Our Ref: WA/28/15/HH

**Town & Country Planning Act 1990 (as amended)
Town & country Planning (Development Management Procedure) (England) Order 2015
Application for Planning Permission for Works or Extension to a Dwelling**

Development Demolition of existing lean-to summer house & erection of single storey extension.
Location Copperfield Cottage Binsted Lane Binsted

BLOCK PLAN
 AREA 90m x 90m
 SCALE: 1:500 on A4
 CENTRE COORDINATES: 499158 , 105338

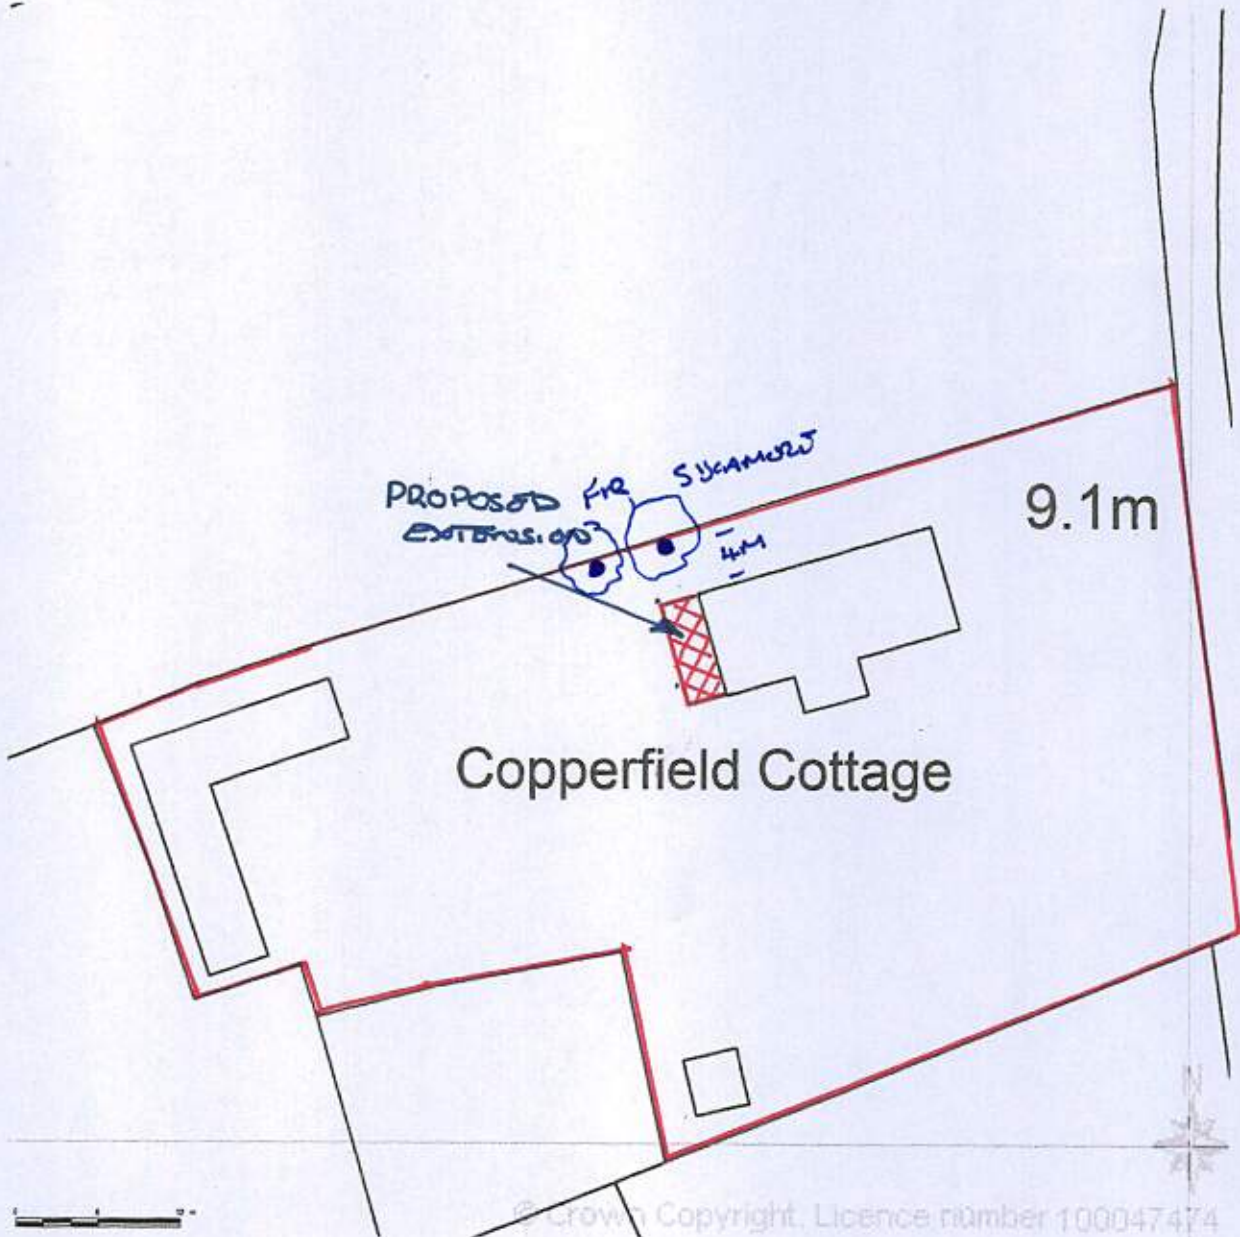
Location Plan

Please submit 1 electronic or 3 paper copies of an amended location plan at a scale of 1:1250 or 1:2500 for rural areas to show 2 road names. Further details of what must be included on the plan can be found in the National Validation Requirements.

CORNERFIELD COTTAGE	
BROUGHT	
PROPOSED EXTENSION	
DRAWING NUMBER	DAT'S
0010/2	MAY 2015
SCALE 1:50	DRAWN BY
	M. WADSWORTH

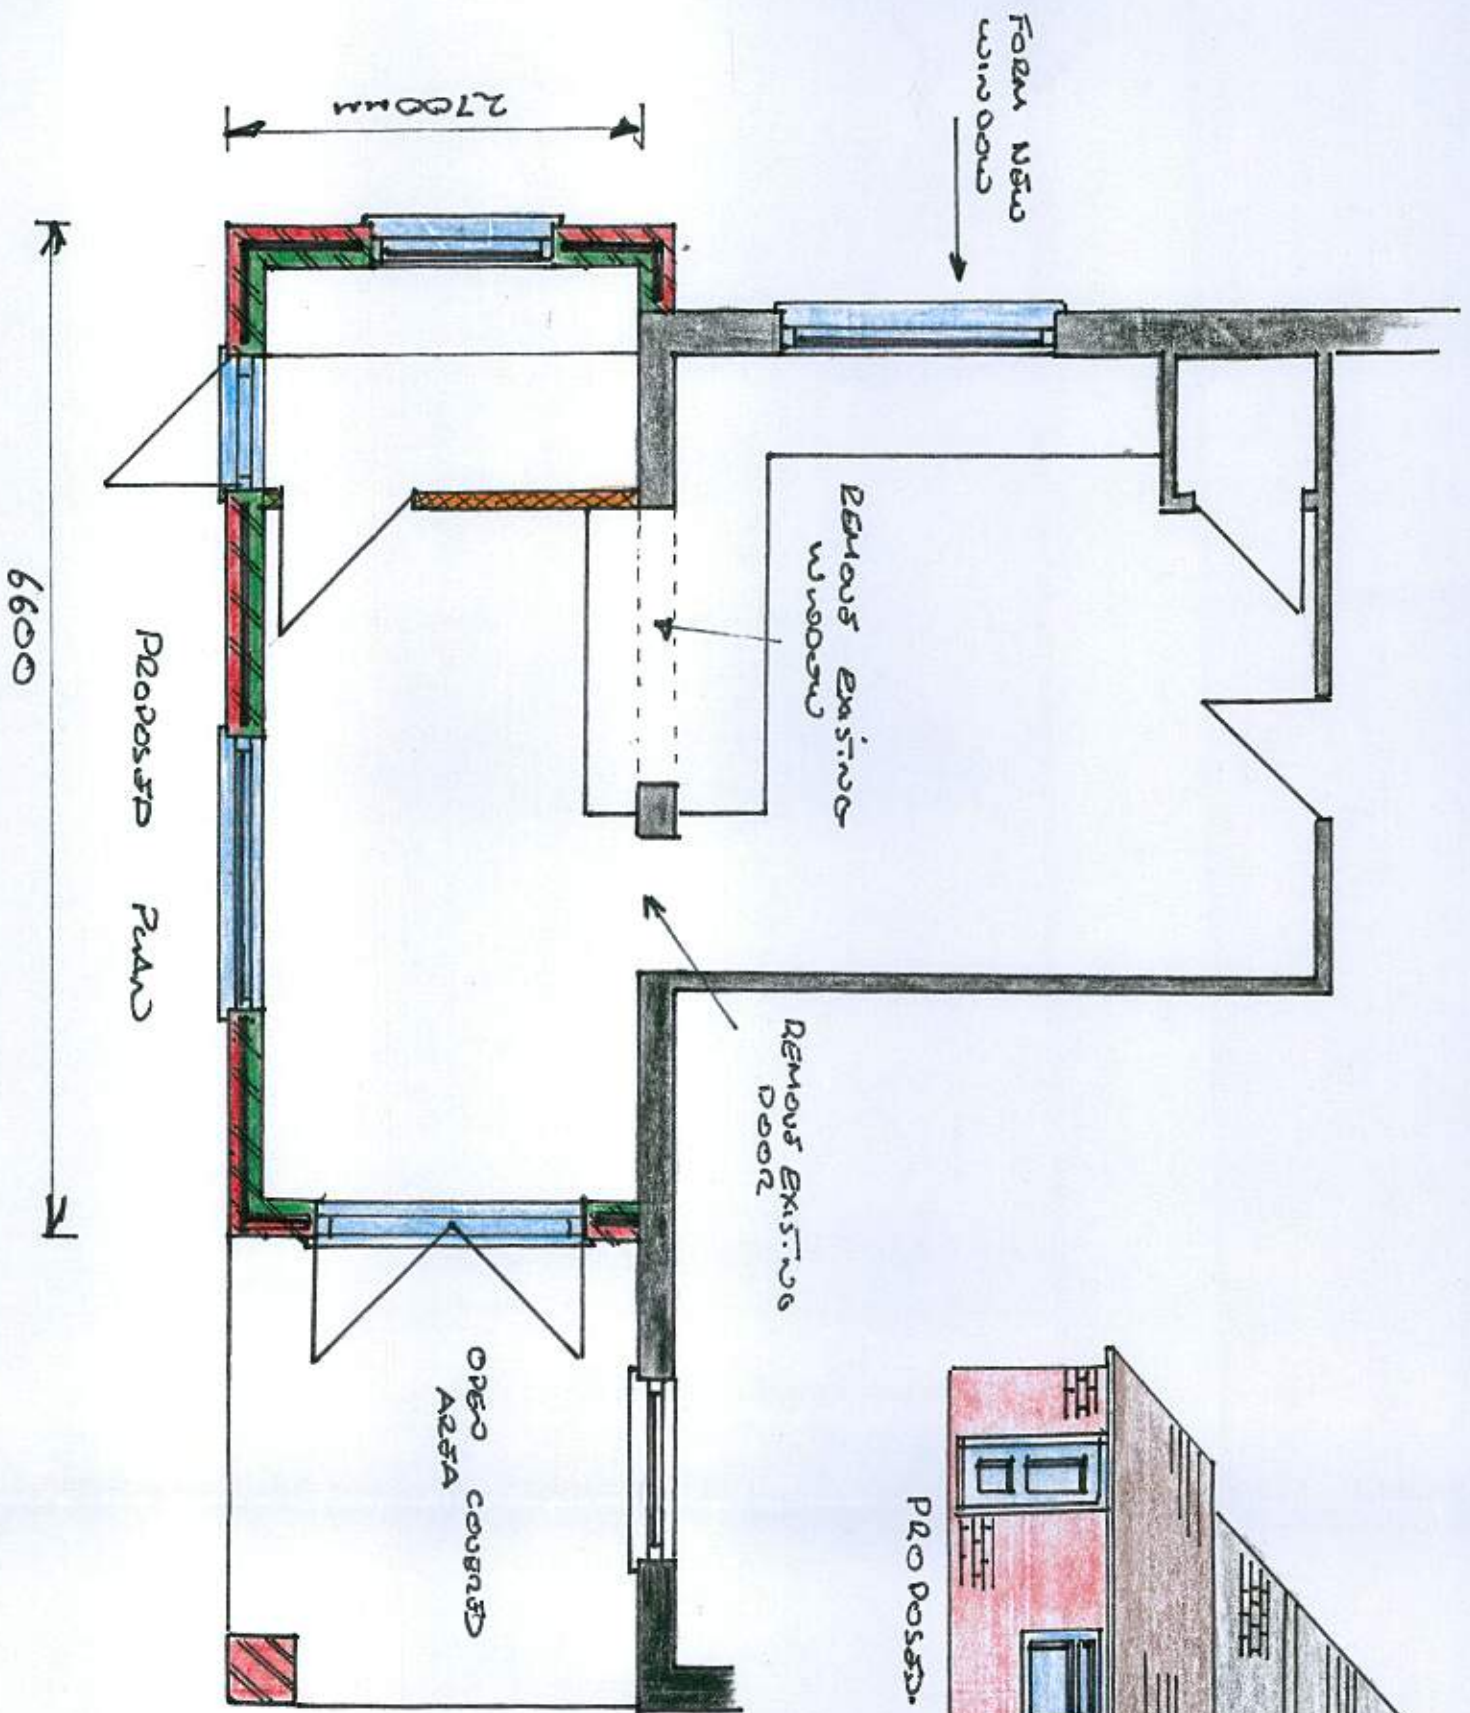
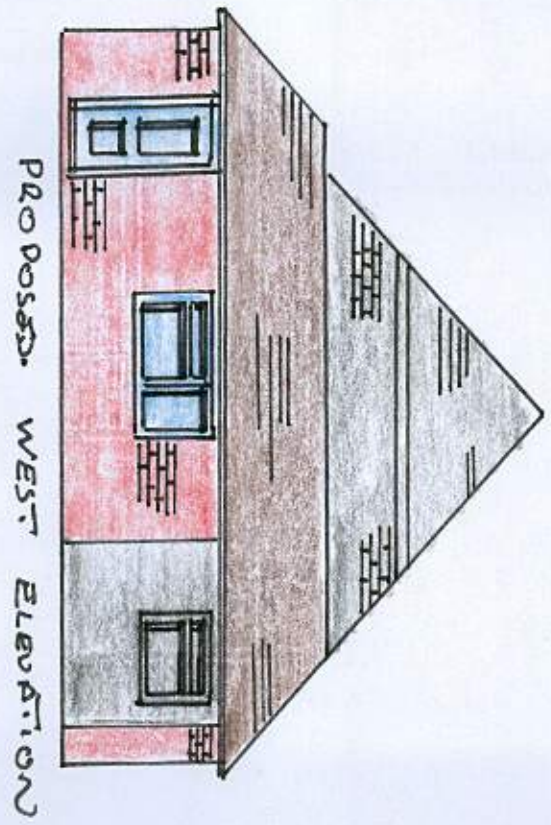
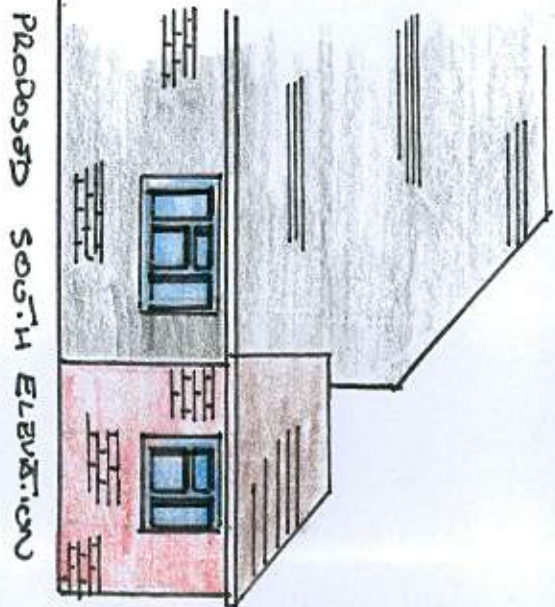
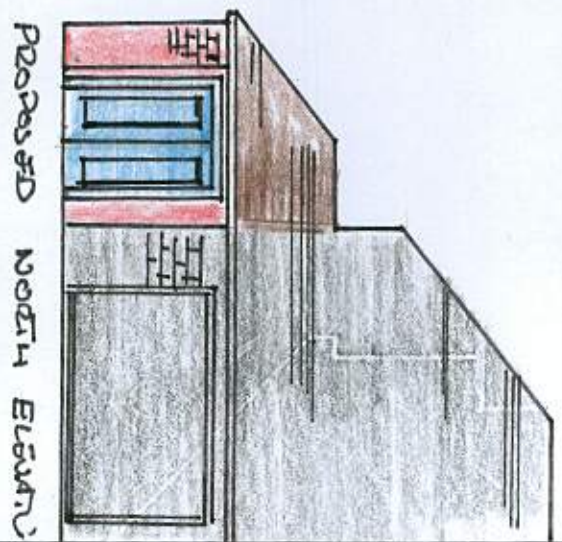
Roof Plan

This extension does not have a flat roof. Please submit 1 electronic or 3 paper copies of existing and proposed roof plan. Please refer to the National Validation Requirements for further details.
